Medworth Energy from Waste Combined Heat and Power Facility

PINS ref. EN010110
Document Reference Vol: 13.6
Revision: 1.0
July 2023

Change Application:

Non-Statutory Consultation report

**Figure 10.1iv**  
**Cromwell Road/New Bridge Lane Signal Scheme - General arrangement**

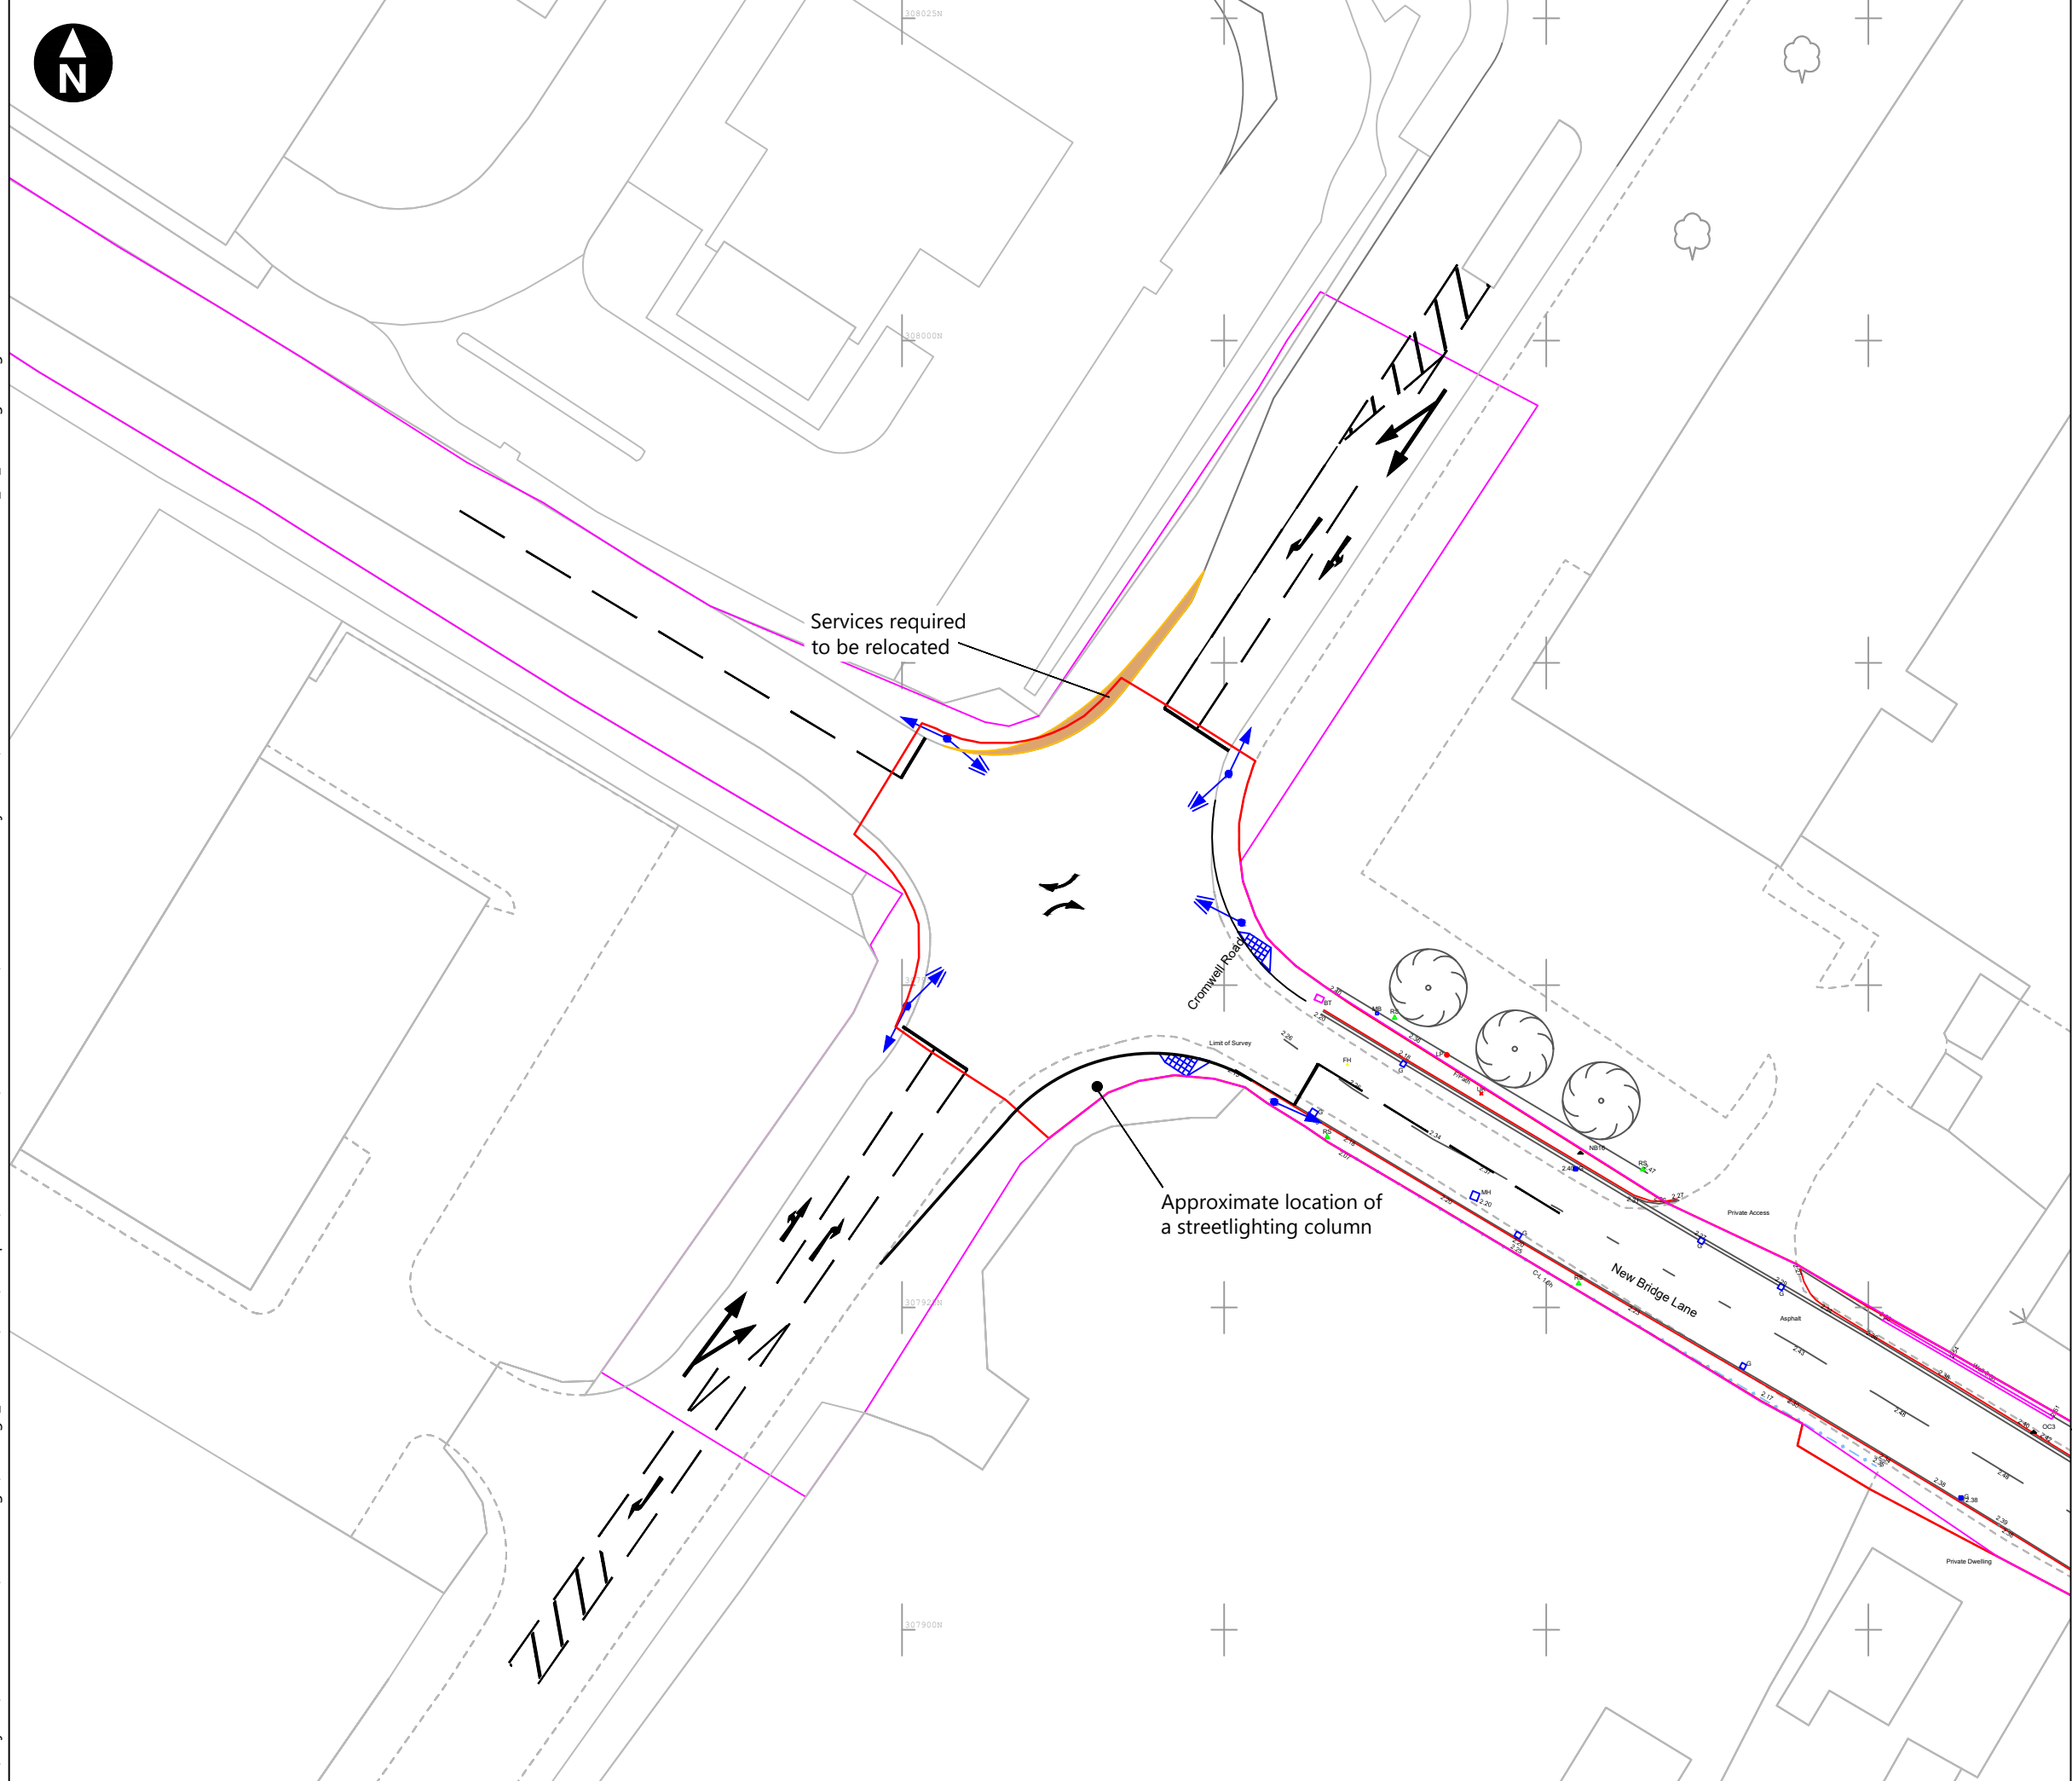
ID	Organisation	Representation	Applicant Comment
		<p>The Councils acknowledge that the Applicant is now proposing to modify the original design to construct central traffic islands, allowing the safe signal control of right turning vehicles from Cromwell Road towards the development. CCC notes that the provided 'Linsig' traffic modelling does not represent the traffic signal staging required for this layout. CCC have provided further information to the Applicant to assist in their signal staging/modelling work and await receipt of further submissions regarding proposed staging and traffic modelling.</p>	<p>notwithstanding that Tesco are fully aware of the impact of Change 1 and have chosen not to make any consultation submission.</p> <p>Therefore, whilst the designation of this land as public highway may not be resolved before the end of Examination, there are contractual arrangements in place under the s278 agreement that should ensure the land relevant to the Change Application is designated as public highway in due course. Notwithstanding, it may be of assistance to the Examining Authority, if CCC were able to advise of their plans to resolve the outstanding issues with the Tesco s278 agreement, and the timescales for doing so.</p> <p>The revision to the original design is at the request of CCC.</p> <p>The Applicant's Transport Assessment (Volume 6.2) [APP-033] did not identify a need to signalise the Cromwell Road/New Bridge Lane junction as the number of right turning vehicles generated by the Proposed Development during construction and operation is very low and junction modelling demonstrated that there is sufficient capacity for the existing junction configuration to accommodate the additional traffic without queuing issues on the Cromwell Road arms. This section of Cromwell Road is 30mph, very straight and there is good visibility for drivers wishing to turn right to see southbound vehicles approaching the junction.</p> <p>The proposed signalisation of the Cromwell Road/New Bridge Lane junction is at the request of CCC due to its concern that an increased volume of slow-moving heavy goods vehicles (HGVs) turning right from Cromwell Road (southern arm) into New Bridge Lane will result in stopping the flow of southbound traffic on Cromwell Road (northern arm).</p>

ID	Organisation	Representation	Applicant Comment
			<p>The inclusion of traffic islands on Cromwell Road within the signal design drawing is consequent to discussions with CCC.</p> <p>Following a meeting with CCC on 6 July 2023, further traffic modelling has been undertaken which incorporates a separate stage for right turners into New Bridge Lane. CCC acknowledged during the meeting that the right turn flows were very low and that this will be called on demand and will not be part of the standard signal phasing.</p> <p>The results of the modelling show that any queues between the Cromwell Road/New Bridge Lane junction and the existing Tesco junction will clear within the green time and will not affect junction operation. The flows on both right turns are very low (84 right hand turns into New Bridge Lane East and 9 right hand turns into New Bridge Lane West in the AM peak which is the busiest scenario), and there is no requirement for a separate right turn stage as part of standard signal phasing – only when required by the presence of a vehicle.</p> <p>It should also be noted that the traffic peaks for HGVs would not coincide with peak hour periods on the network generally and therefore the traffic modelling is presenting a very worst-case scenario.</p> <p>It is also noted that 5% of operational traffic would be on Saturday and Sundays and therefore weekday traffic flows will be lower than presented in the assessment work.</p> <p>During the meeting with CCC on 6 July 2023, CCC advised acceptance of the Stage 1 Road Safety Audit (RSA), which was undertaken in May 2023 by independent specialist consultants, and the Designers' Response (ES Chapter 6 Traffic and Transport Appendix 6B Transport Assessment Addendum (Volume 3.11) (the TA Addendum), [AS-029]). The Applicant will continue to work with CCC on the detailed design of this junction.</p>
